**Consultation Response from Mike Hibbert,
KC Waste Strategy(Refuse & Recycling)**

2024/90255 Land Off, Burn Road, Birchencliffe, Huddersfield, HD3 3BT

Reserved matters application, including the considerations of appearance, landscape, layout, and scale for the erection of 26 dwellings pursuant to outline permission 2019/94051 (outline application of up to 39 dwellings and associated works), discharge of conditions 27 (Arboriculture Assessment), 28 (Ecological Assessment), 29 (Public Right of Way)

Responding Ref: WPS 24- 009

DRAWING TITLE
VEHICLE TRACKING DRAWING

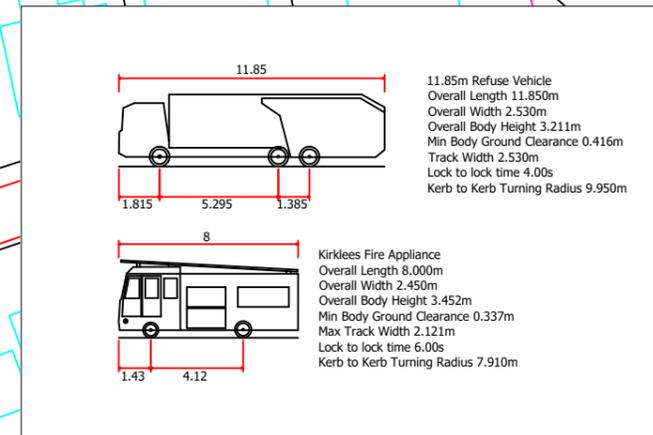
- Where turning is necessary, the turning facilities must be demonstrably sufficient for an 11.22m refuse collection vehicle. **Active measures should be taken to prevent parking in the turning head as otherwise an RCV would have a very long reverse manoeuvre to the entrance to the site that is a recognised safety risk and is not acceptable.**

- Swept path analysis must show the manoeuvrability of this vehicle throughout the site, demonstrating the safe passing of other vehicles likely to be using the road – either parked or moving.
